Your Ref: OWPC20770
Our Ref: LU/324/18/PL 12-11-2018
Please ask for:
Mrs A Gardner

Demolition of existing hotel & replacement with new 14 bedroom hotel with ancillary restaurant & function rooms.

The Nelson Hotel 61 Pier Road Littlehampton

REAR ELEVATION (NORTH)

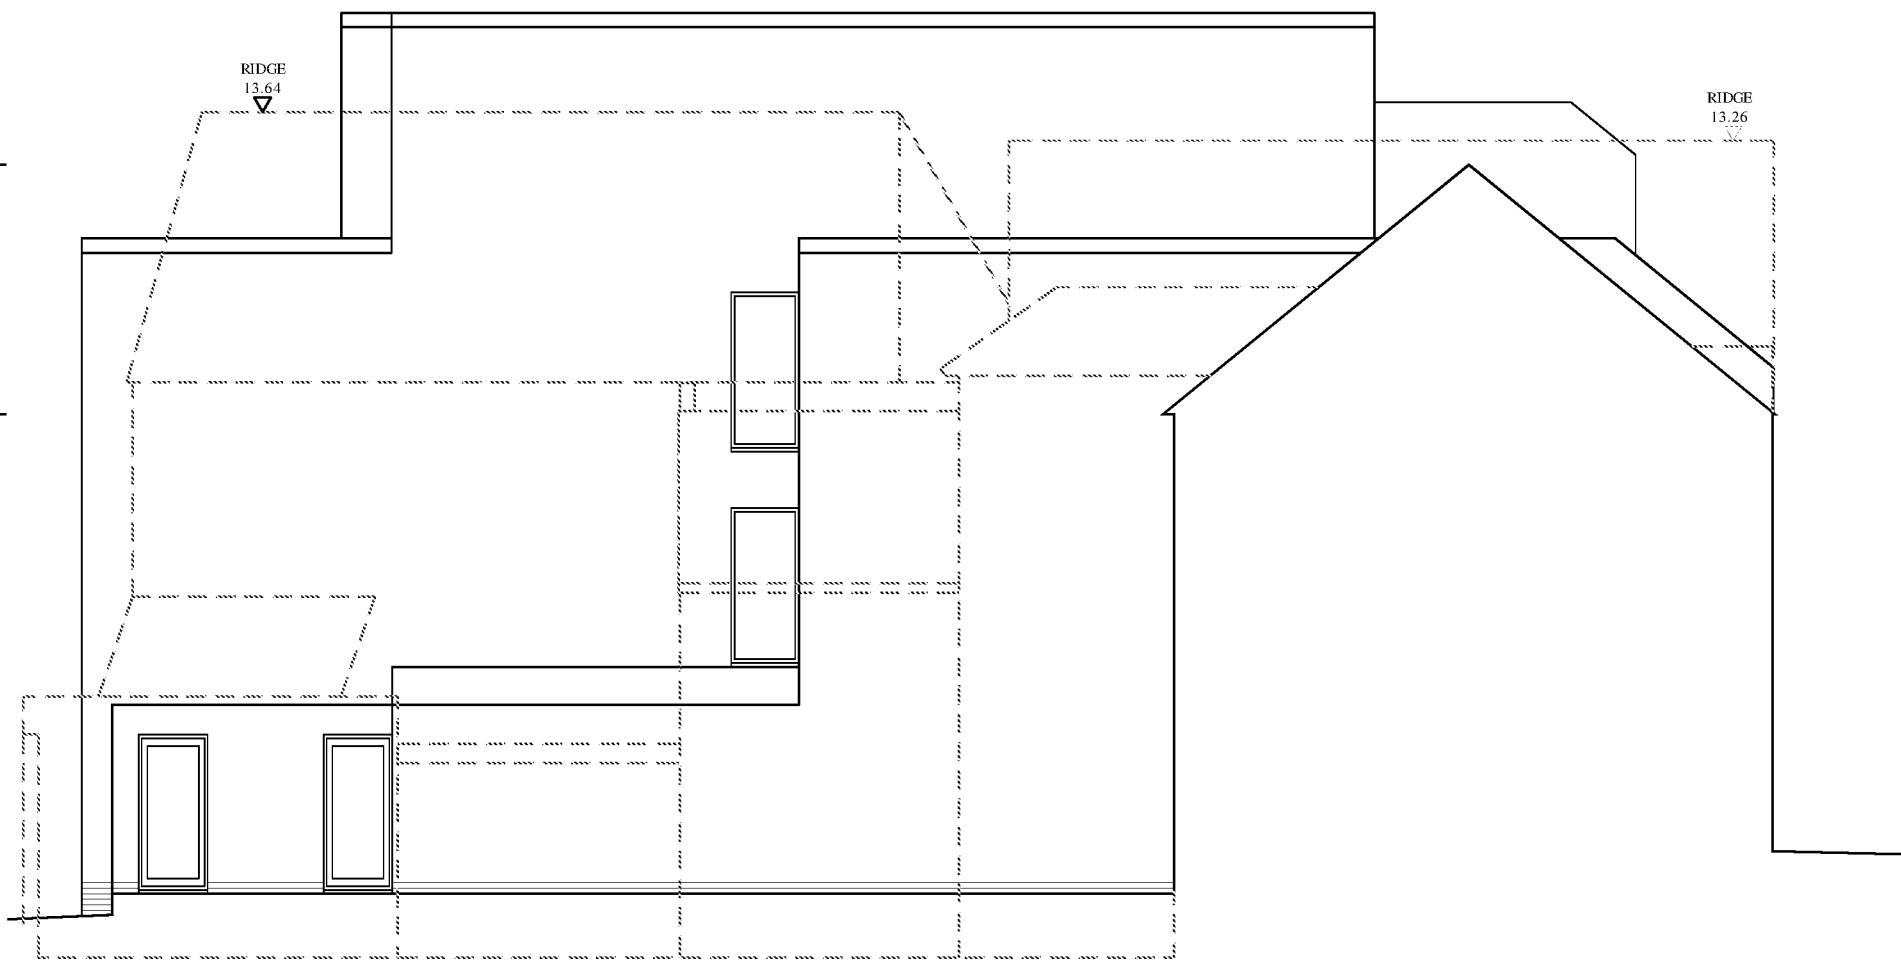
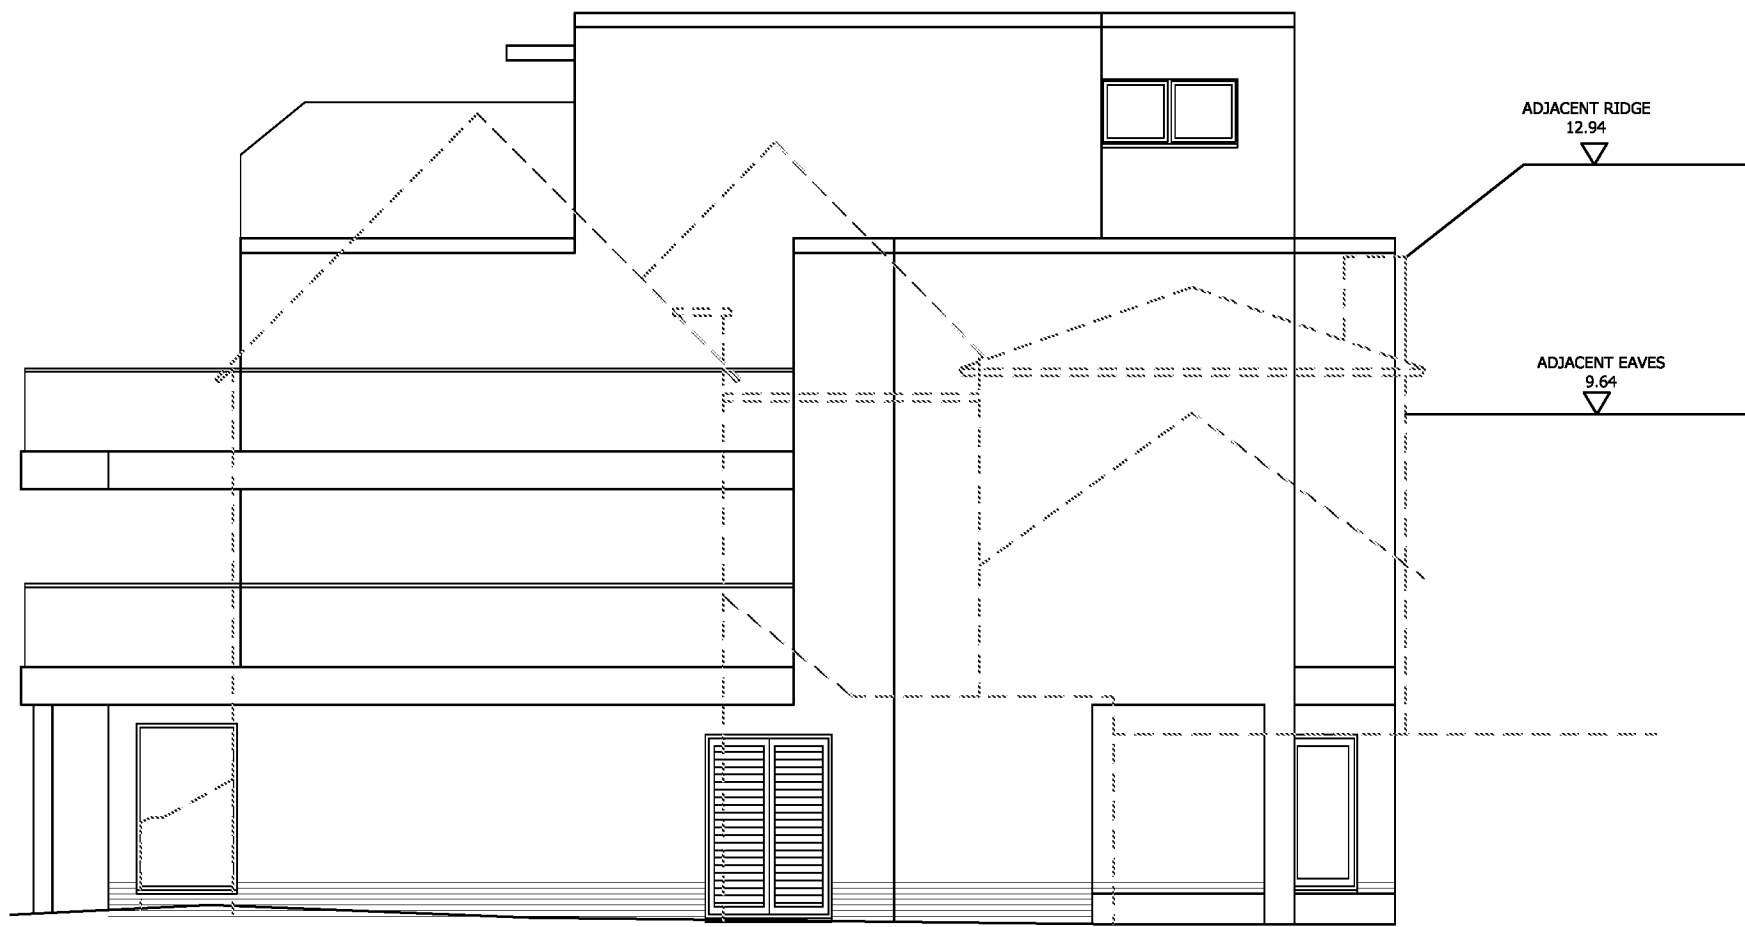
Would it be possible to have no north facing windows facing into the back yard of #60 Pier Road, say until the 4th floor so that any future possibility of rearward extension of #60 is not compromised?
